**Consultation Response from KC,
Trees**

2025/90768 Land Adj, 2, Hopton Hall Lane, Upper Hopton, Mirfield, WF14 8EP

Erection of detached dwelling and associated external works

Date Responded: 10/04/2025

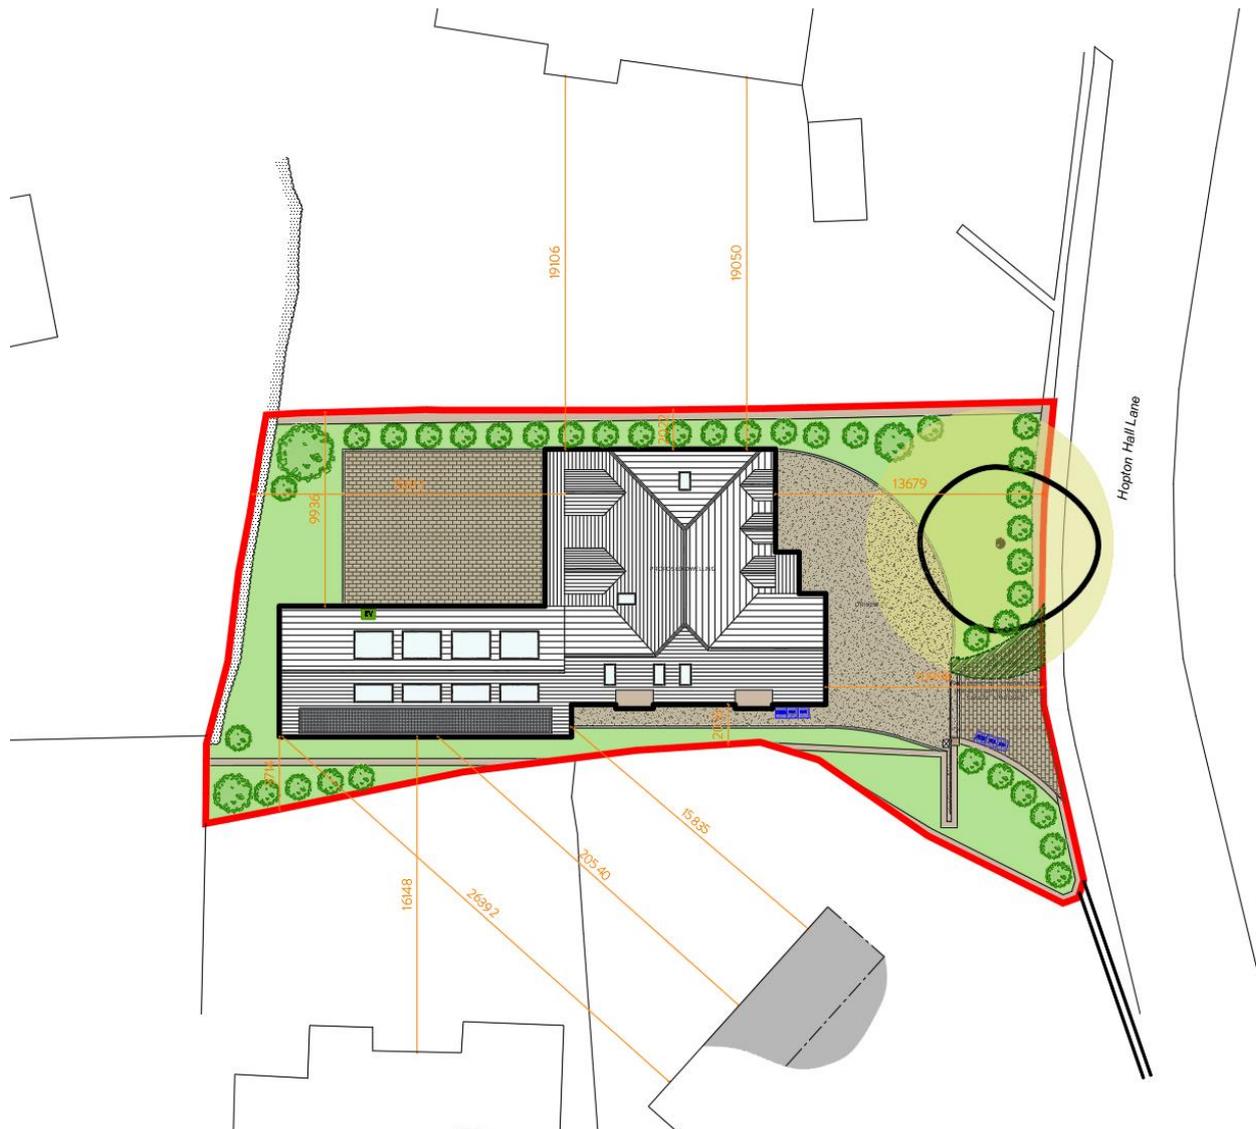
If I go on the drawing inserted in the Covering Letter that accompanied the application, I can see a very minor tweak to the layout. However, I reject Edward Gribbin's suggestion that there is only a 6% incursion into the RPA of the protected tree, as this appears to refer only to the incursion for the access. The larger area of proposed Cellweb driveway is also partially within the RPA of the protected tree and must also be considered.

As I stated previously, these proposals cause concern from an arboricultural perspective, as the total overlap of the driveway and access route covers a significant portion of the total RPA. According to BS5837: 2012 new permanent hard surfacing should not exceed 20% of any existing unsurfaced ground within the RPA.

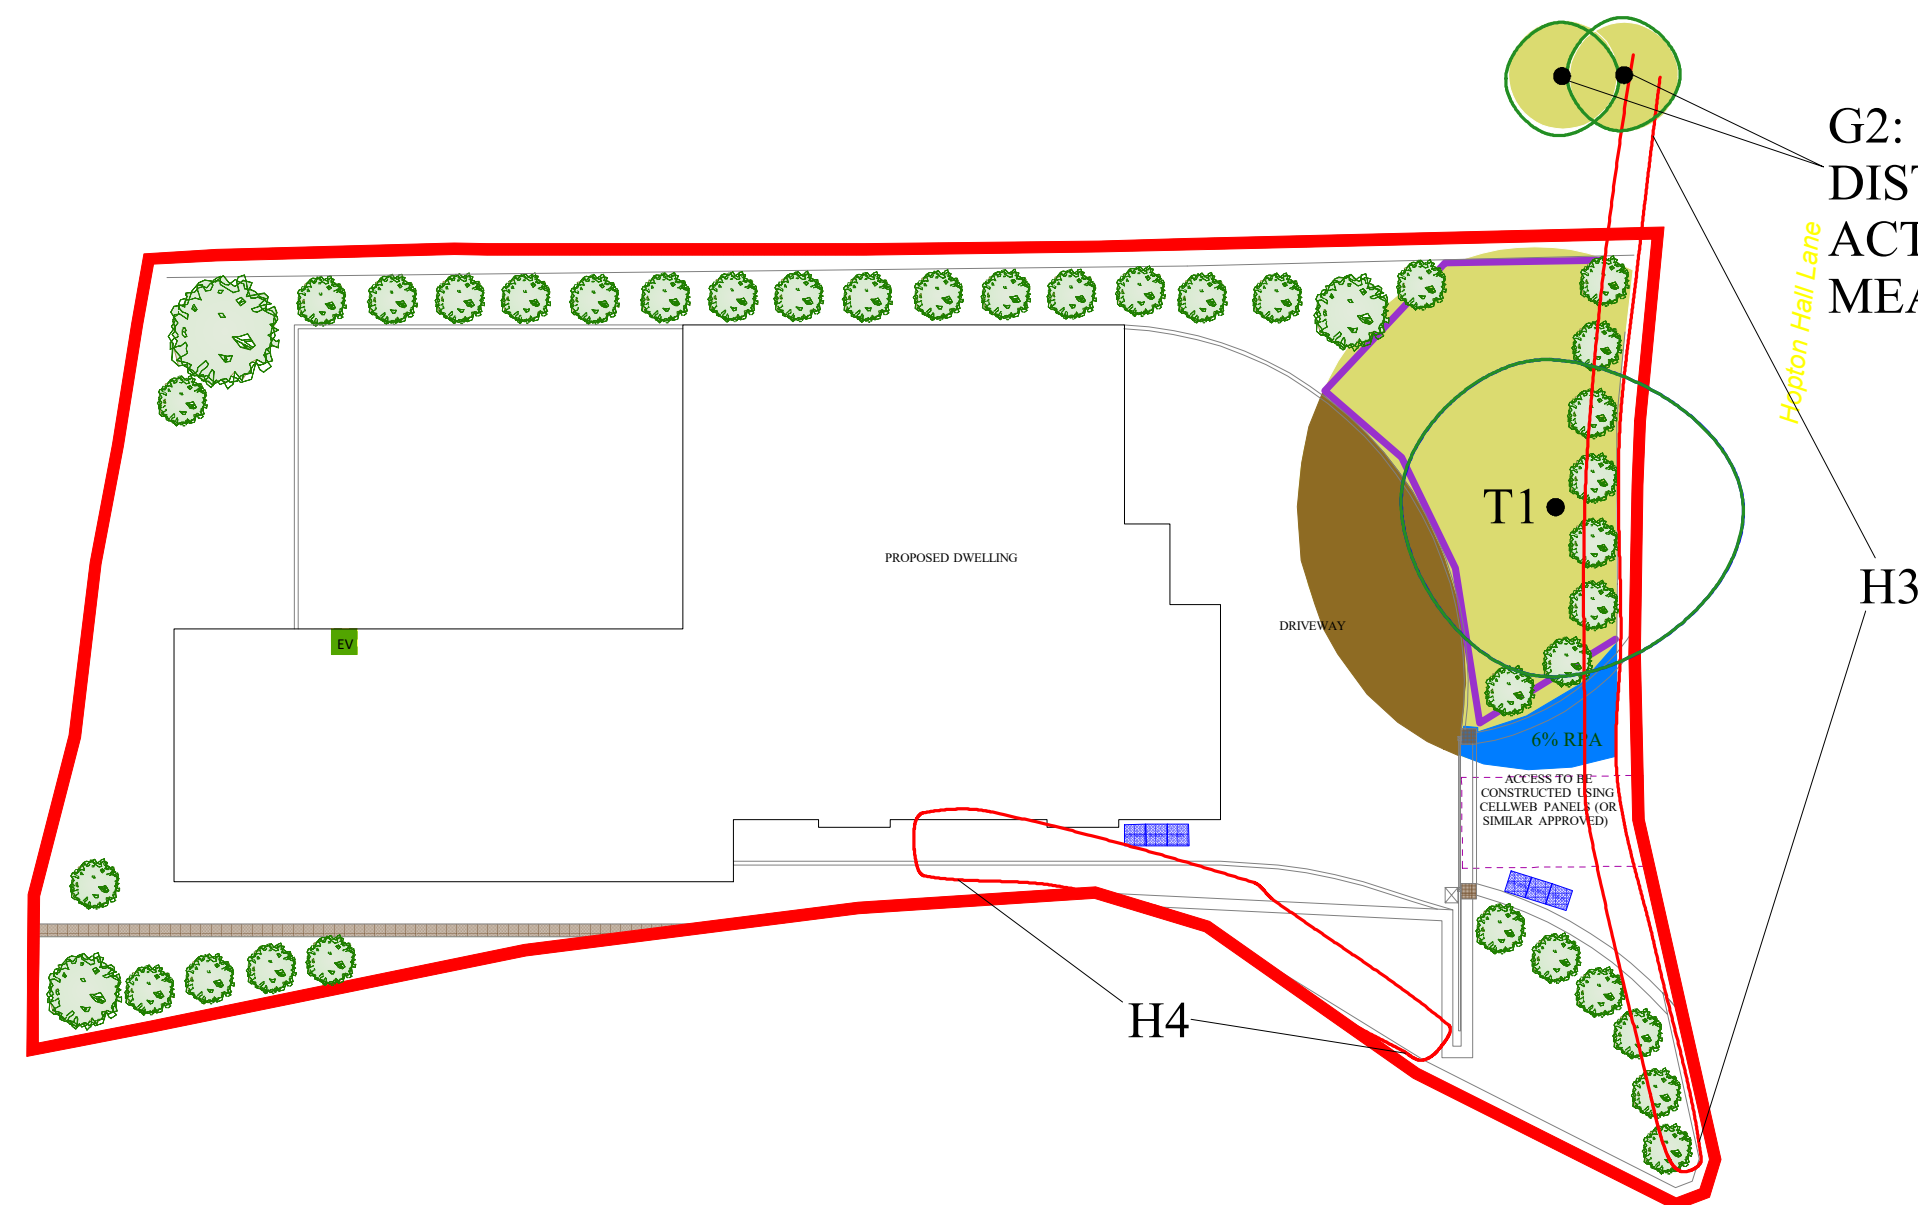
Having reviewed the amended AIA, I can see no changes to the tree protection plan. Perhaps the applicant has submitted the previous version of the AIA in error instead of the amended copy?
